A47 Wansford to Sutton Dualling

Scheme Number: TR010039

9.34 Request for a Non-Material Change to the Application

**9.34 REQUEST FOR A NON-MATERIAL CHANGE
TO THE APPLICATION**

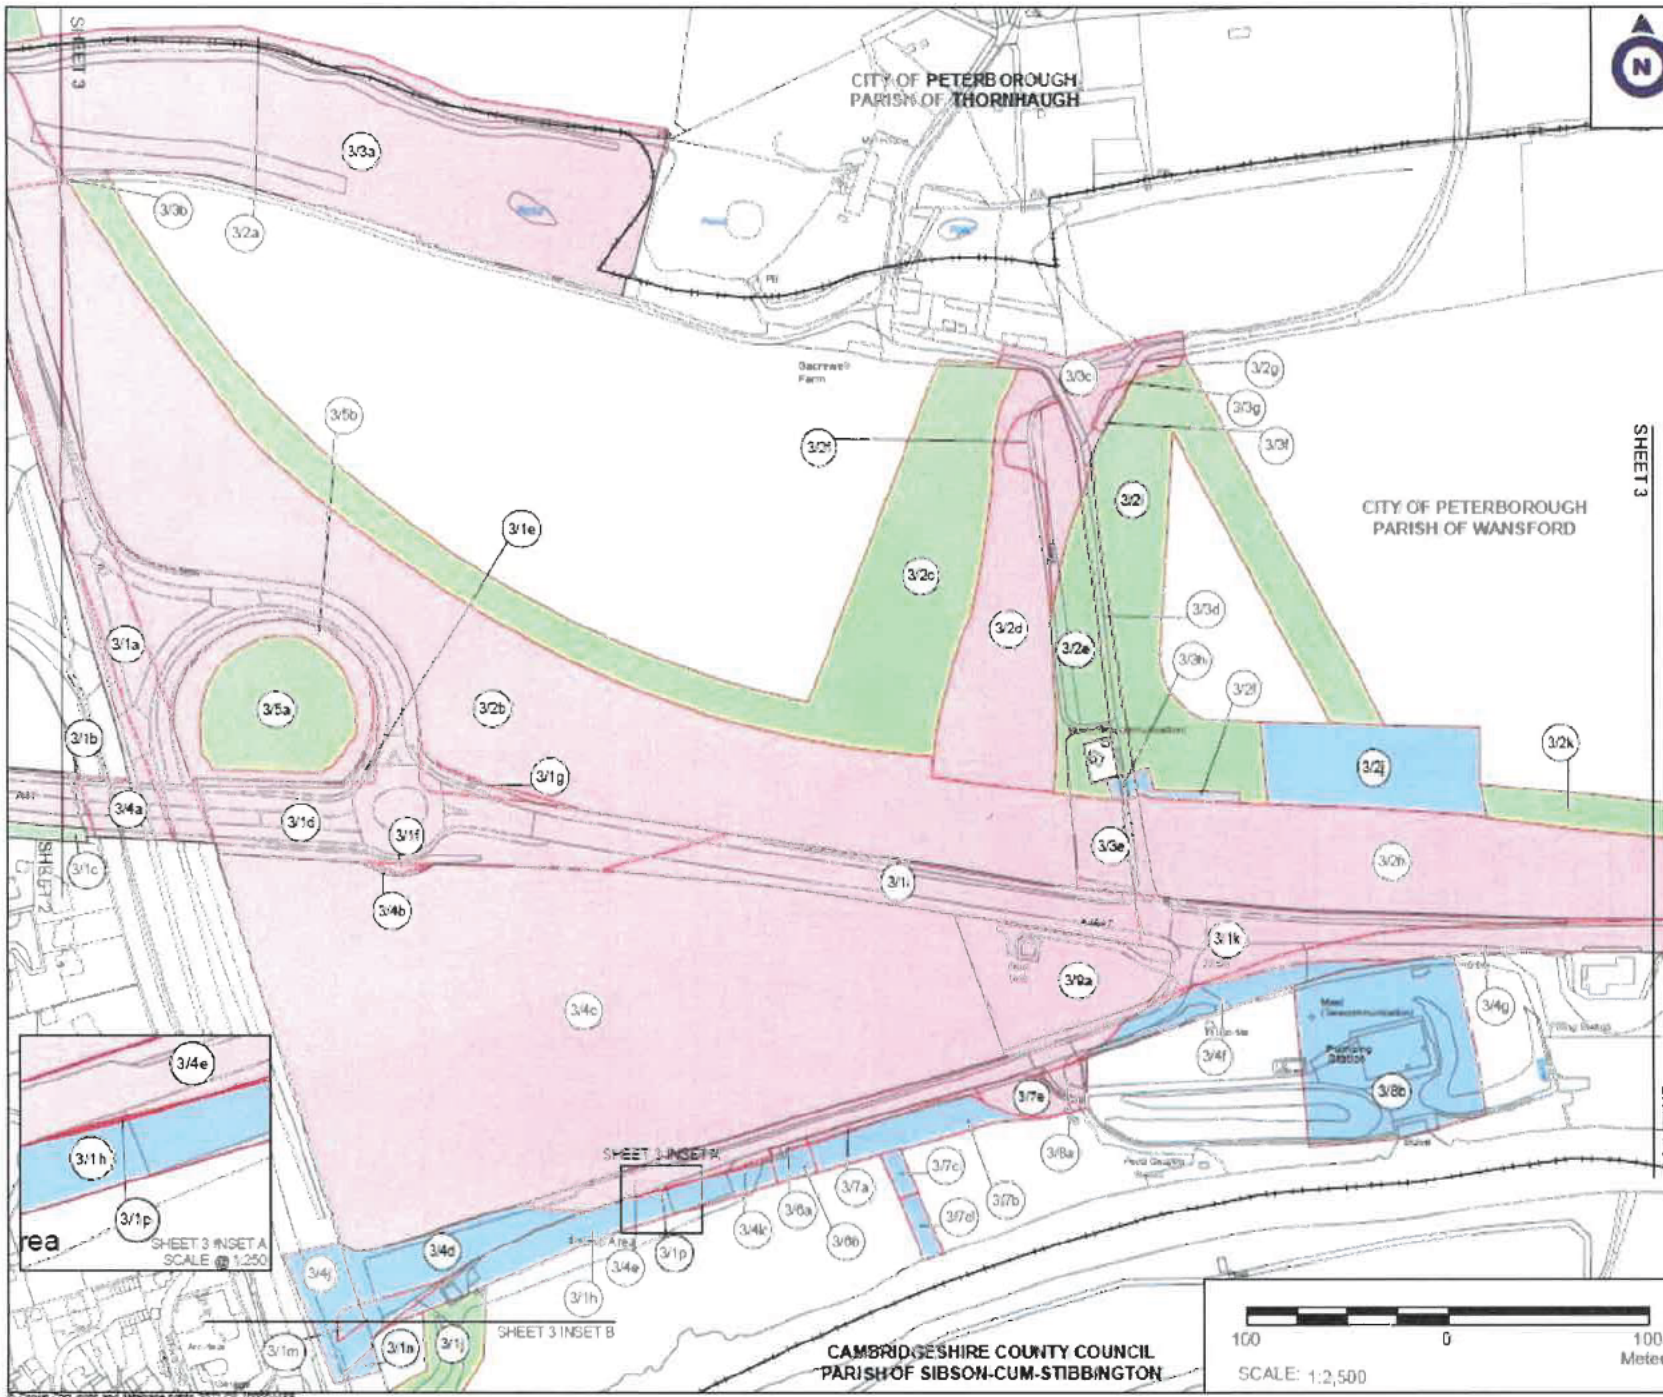
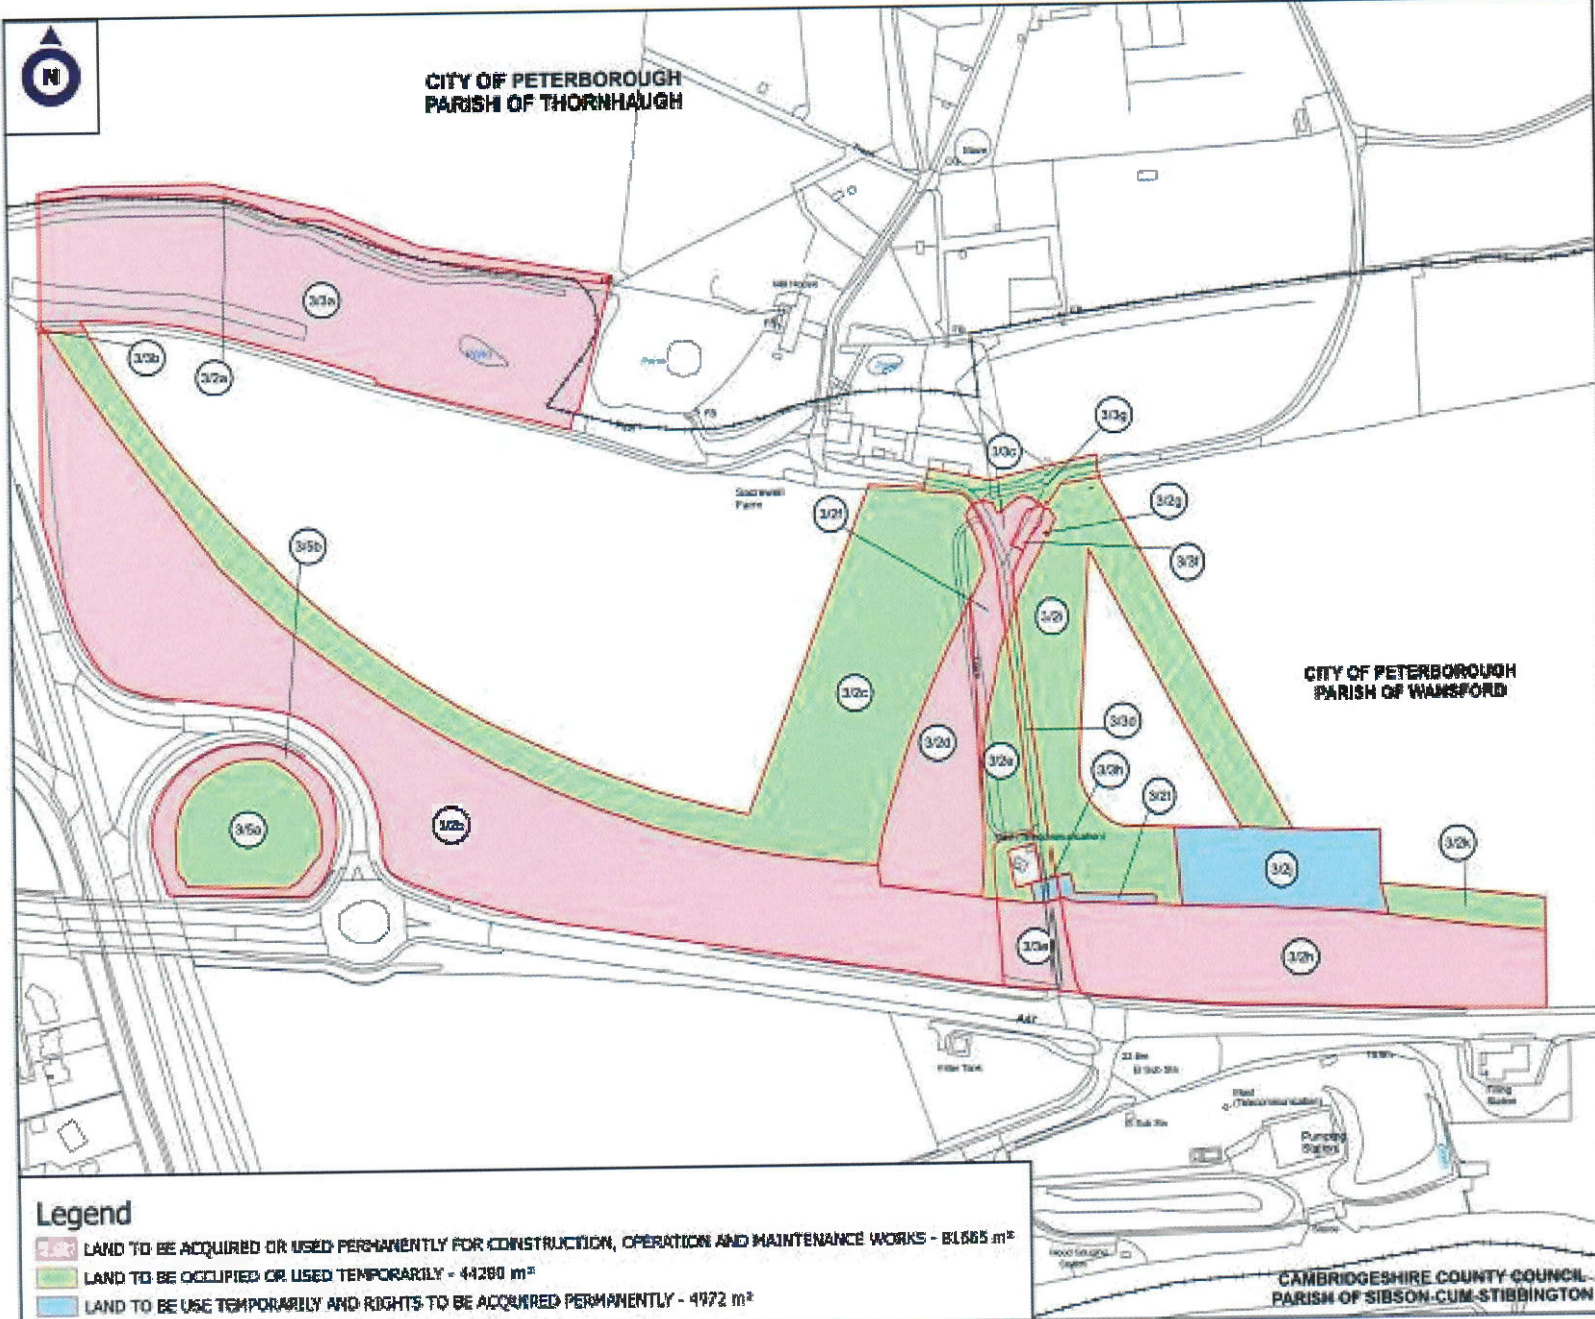
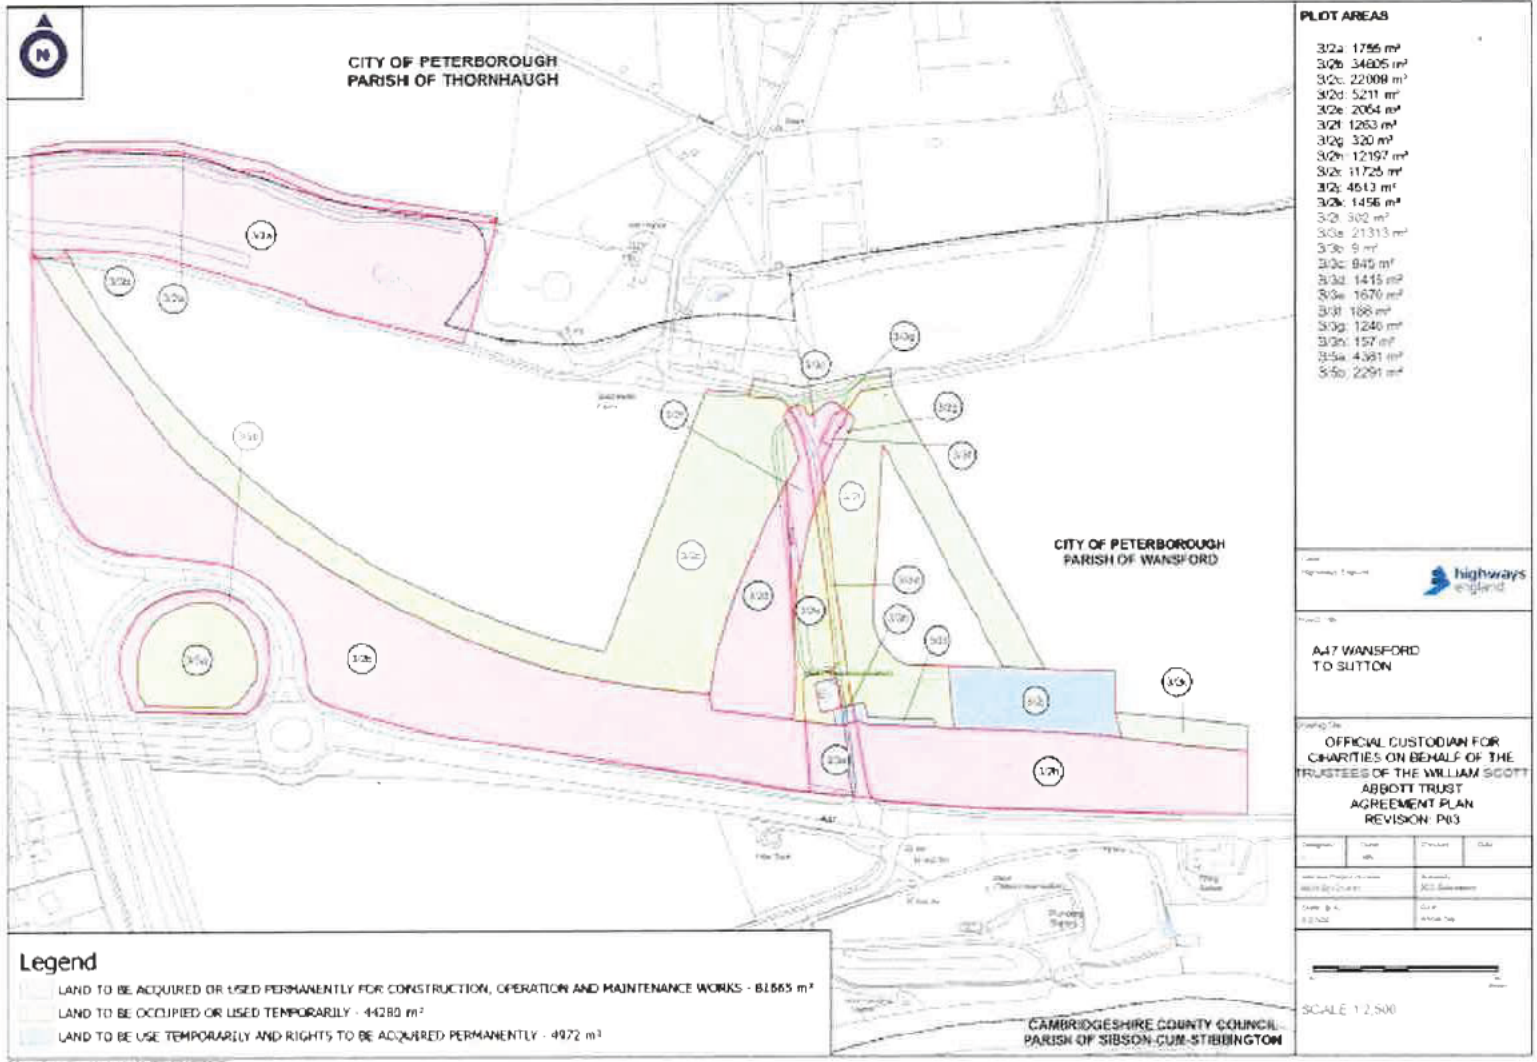
- 2.1.5 **Change Two:** Modification to the means of access alignment to Sacrewell Farm to avoid interface with Anglian Water assets shown on revised Works, General Arrangement, Rights of Way and Land plans sheet 3. This layout improves the visibility at the access to Sacrewell Farm and also addresses the ExA's query at Hearing Action Point 38 (EV-021) and the Applicant's initial response regarding use of a convex mirror to improve visibility in **REP5-020**. Please note as a result of Change Two, work number 23 of the submitted Works Plans is deleted but the work number is re used to show new works as a result of Change One on the revised Works Plans sheet 3.

- 2.1.7 As a result of Change Two, land for permanent acquisition and temporary possession is altered and shown on the revised Lands Plans Sheet 3. Further details on the proposed changes to the Land Plans are set out below.

- 5.1.4 Taking into account the ExA's guidance in **PD-013**, the Applicant has renumbered the plots which are subject to this change request. The relevant plots are shown on the revised Land Plan Sheet 3 which also now shows the proposed changes to the access to Sacrewell Farm.

- 5.1.5 The re numbering exercise has however meant that more plots are affected by the Change 2 as follows

3/2c – was 19003.17 sq m, now 22009.08 sq m - additional temporary possession land

3/2d – was 34539.10 sq m, now 5211.27 sq m – additional permanent acquisition land

3/2e – was 2343.91 sq m, now 2053.52 sq m – reduced temporary possession land

3/2f – was 1659.63 sq m, now 1263.34 sq m – reduced permanent acquisition land

3/2g – was 134.96 sq m, now 320.00 sq m- additional permanent acquisition land (Note: previous location of 3/2g is now incorporated in 3/3g and 3/2i both now for temporary possession – see below)

3/2i – was 11910.57 sq m, now 11725.18 sq m – reduced temporary possession land

3/3c – was 1999.83 sq m, now 845.27 sq m – reduced permanent acquisition

3/3d – was 1494.33 sq m, now 1414.58 sq m- reduced temporary possession land.

3/3f – was 188.08 sq m, now 186.45 sq m – reduced permanent acquisition land

3/3g – 4.31 sq m, now 1240.24 sq m – additional temporary possession land
